# BUILDING PERMIT REPORT

DATE: 15 Dec 98 ADDRESS: 72 Torrington Ave. CBL 084-N-014  
REASON FOR PERMIT: Amend original permit #970537  
BUILDING OWNER: Kane  
CONTRACTOR: Scottsdale Const  
PERMIT APPLICANT: owner  
USE GROUP R-3 BOCA 1996 CONSTRUCTION TYPE 5 B

72 Torrington Ave.
 2nd Floor Proposed Plan
 Dec. 1998

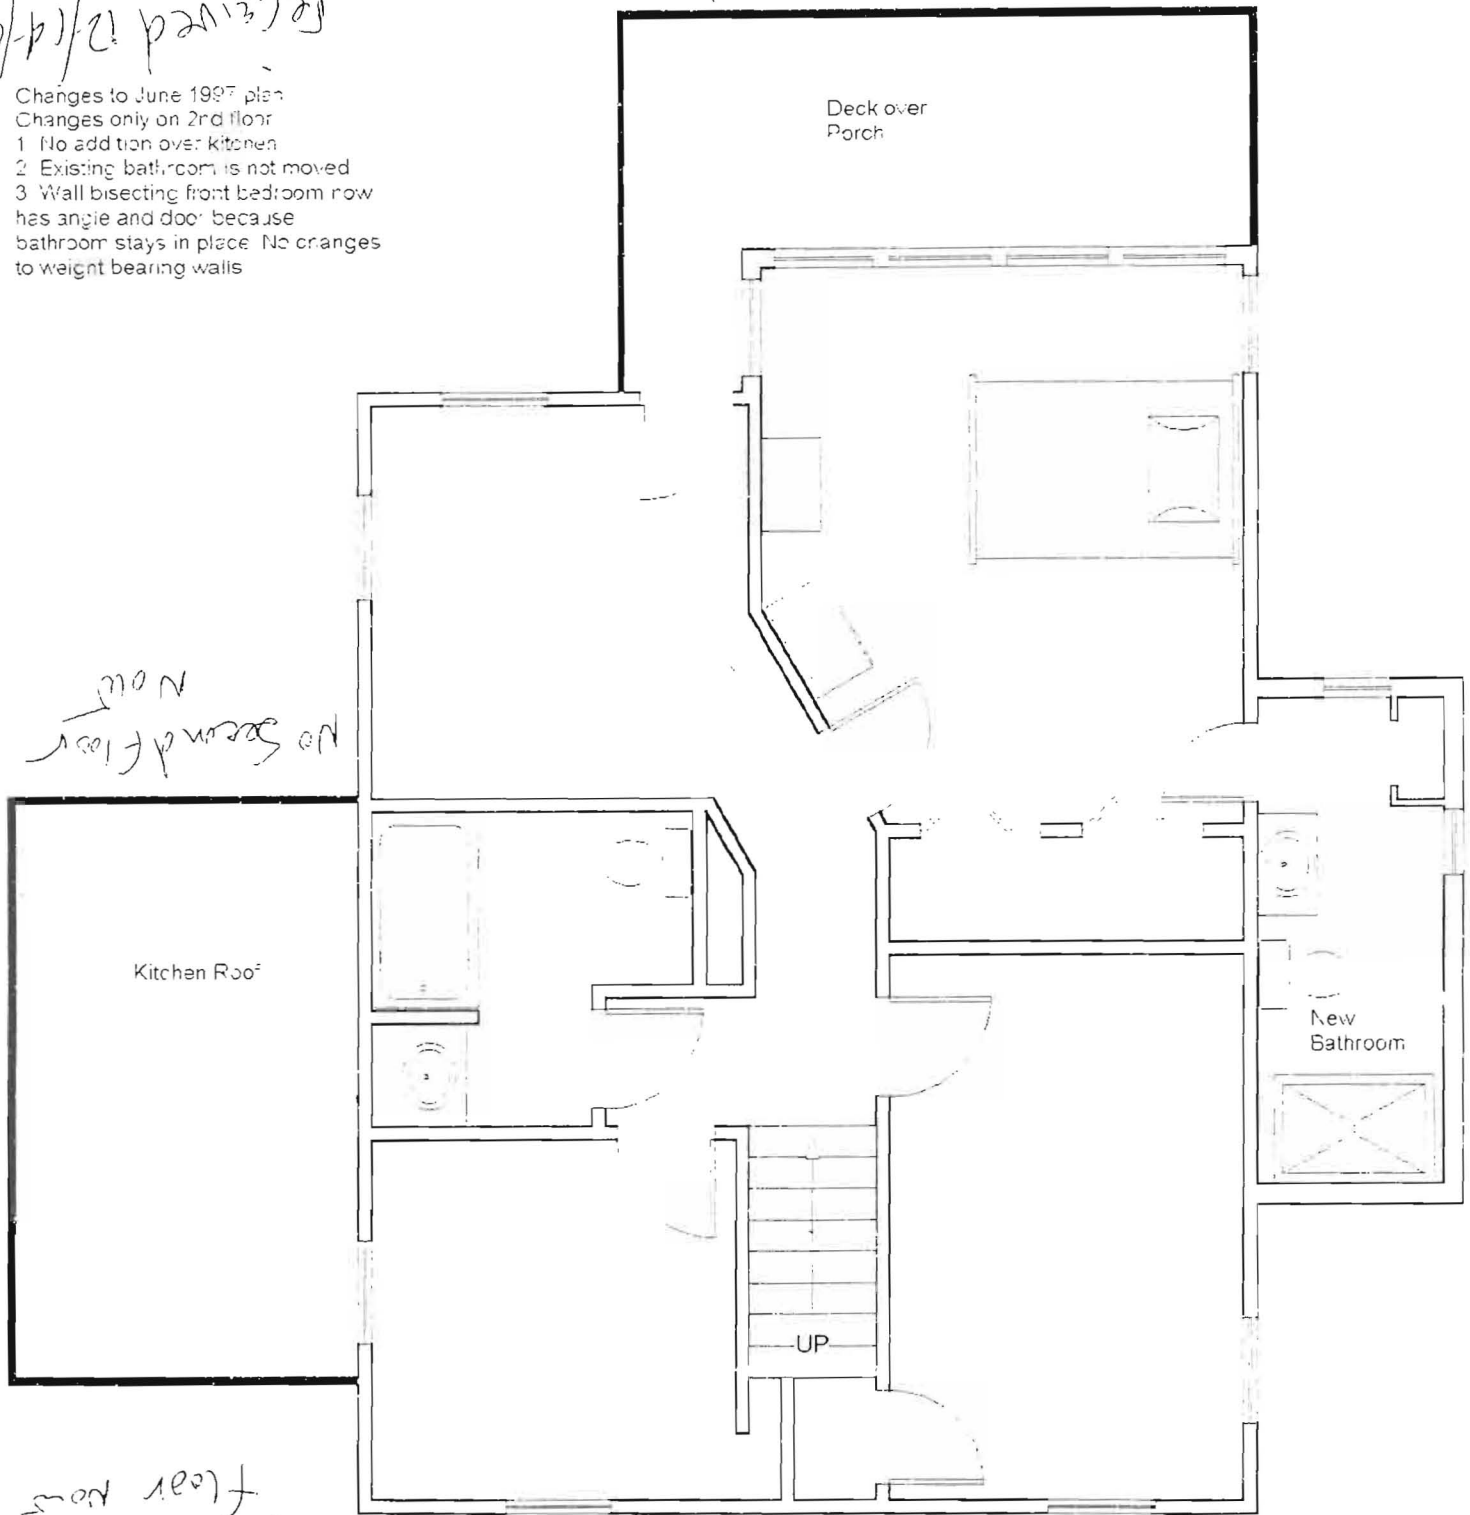
31. *Your plan did not show a Framing detail of The expansion of The Second Floor bedroom over The porch - Please submit this detail as soon as possible -*
